Project Name:	Land at Bayards, Eastergate (Miller Homes)
Document Reference:	091.5016/SVR/2.2
Document Name:	SuDS Verification Report – Area 2
Prepared By:	Samuel Flesher
Checked By:	Meagan Weedon
Approved By:	Jon Soar

- 1.1 This Sustainable urban Drainage Strategy (SuDS) Verification Report – Area 2, has been prepared by Paul Basham Associates on behalf of Miller Homes to support the 'As-Built' verification report to Arun District Council in relation to Land at Bayards, Eastergate.

- 1.2 This Verification Report has been prepared to support the discharge of Planning Condition 24. The report authors are Paul Basham Associates Ltd. Paul Basham Associates were established in 2009 and are a multi-disciplinary Transport Planning, Civil and Structural Engineering Consultancy, employing a team of Civil Engineers.

## Section Pictures – 12/09/2023 – PSCP203

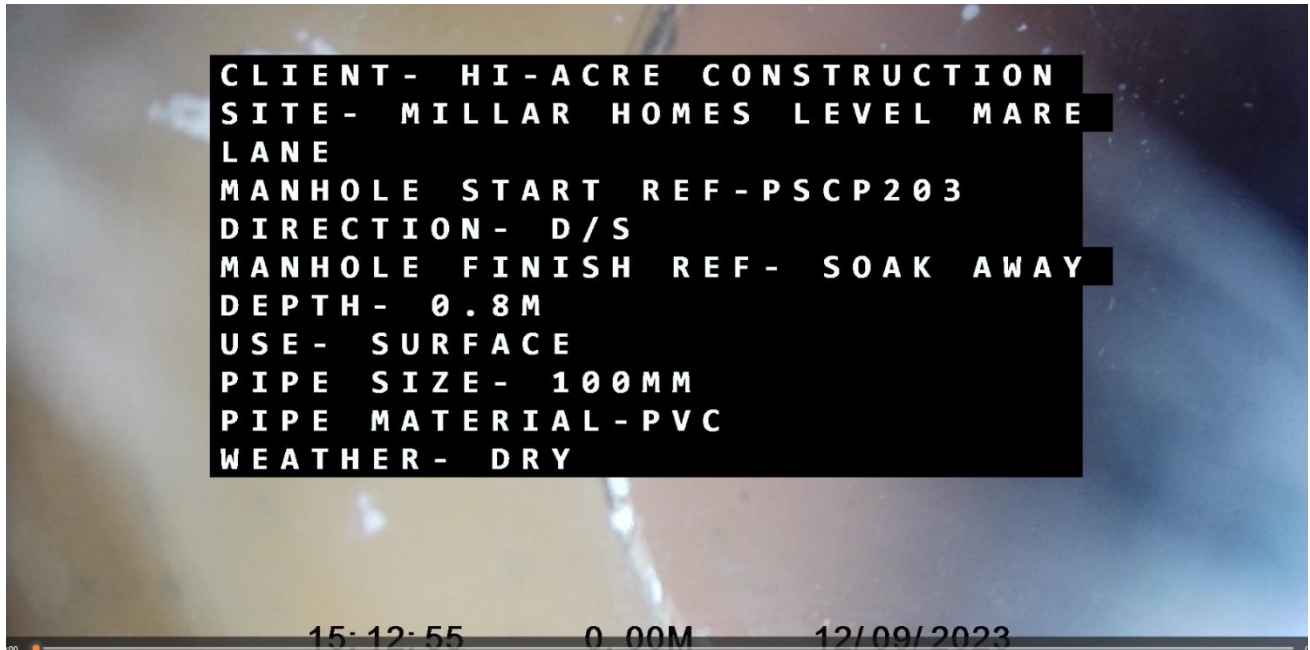
S206-SA64-SA65		Pipe with spiral splits shown, pipe has deformed and no longer circular. Pipe also appears to be bent and changes direction without a junction.
PS202-PSCP203		No visible major defects
PS203-SA64-65		Pipe with spiral splits shown, pipe has deformed and no longer circular. Pipe also appears to be bent and changes direction without a junction.
PS221-PSCP220		No visible major defects
PSCP220-SA53		No visible major defects, pipe run appears to end in a bend into the top of crate system
PS54-PSCP220		No visible major defects
PS344-PSCP342		Footage starts at -10m and shows a pipe bend at 0m the 4.7m upstream of PSCP342. No joint for rainwater pipe.
PS342-SA57-63	Footage not provided

## Section Pictures – 12/09/2023 – PSCP217

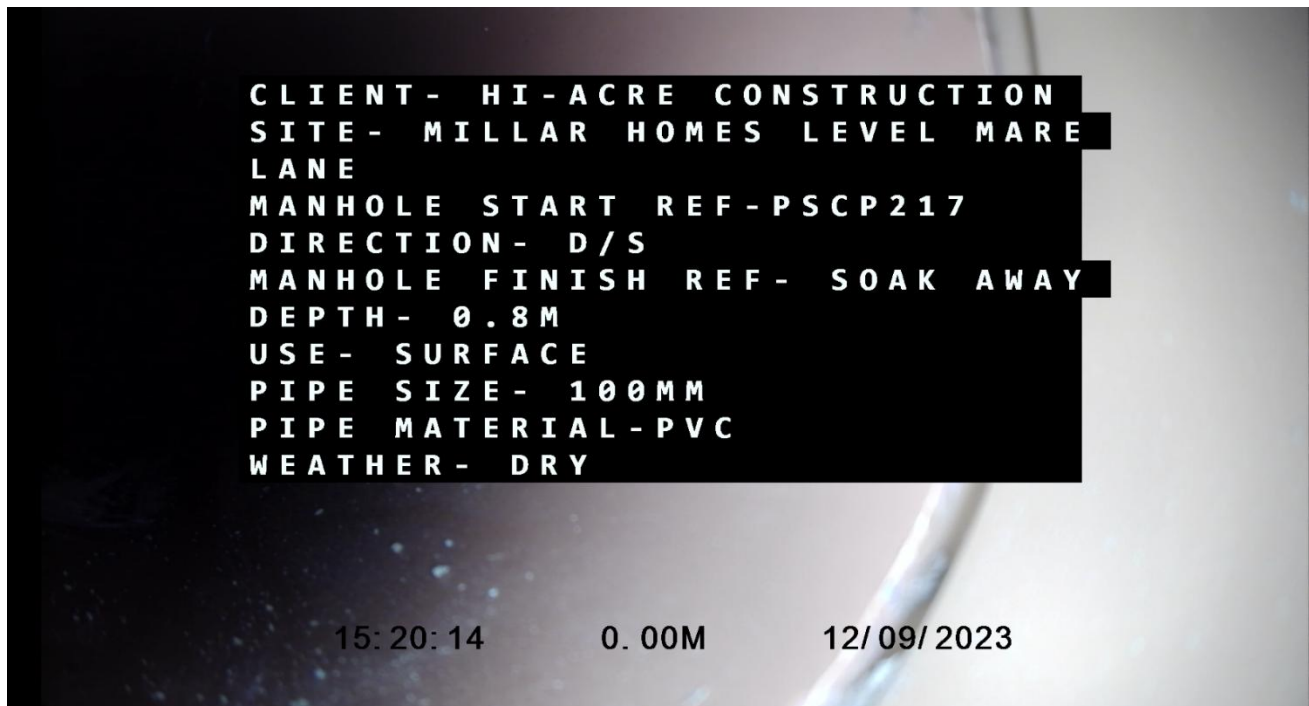
Ref	Defect Images	Comments
PS216-PSCP217		Imagery very blurry and camera light appears to be dim. Appears to be no defects to the pipe
PSCP217-SA50		Pipe has snapped at the point where pipe rests on crates.
PS209-PSCP210		Imagery very blurry and camera light appears to be dim. Appears to be no defects to the pipe
PS210-SA66-67		Connection into side of infiltration crate, appears to be PolyStorm crate unit. Membrane is slightly protruding into pipe. No other visible defects.
PS212-PS213		No major defects
PS213-SA66-67		Pipe with spiral splits shown, pipe has deformed and no longer circular. Pipe also appears to be bent and changes direction without a junction. Drainage approach differs between plots 66 & 67, contractor to confirm if this is correct.
PS5251-S206		Appears to be a small amount of water build up at start of survey due to sediment in the pipe. No other major visible defects.

**PS61**

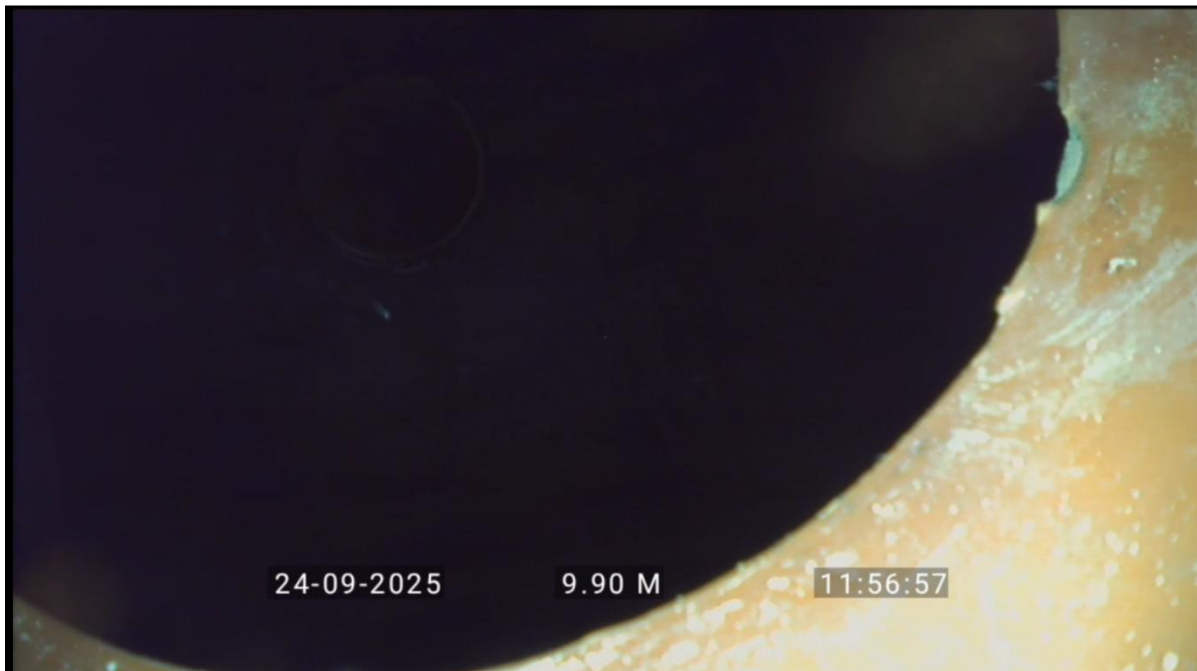
PS5281-PS61		Footage shows a pipe junction, design shows no junction into this pipe.
PS61-SA57-63		Pipe appears to run into the top of the crates with a bend at the end of the pipe.
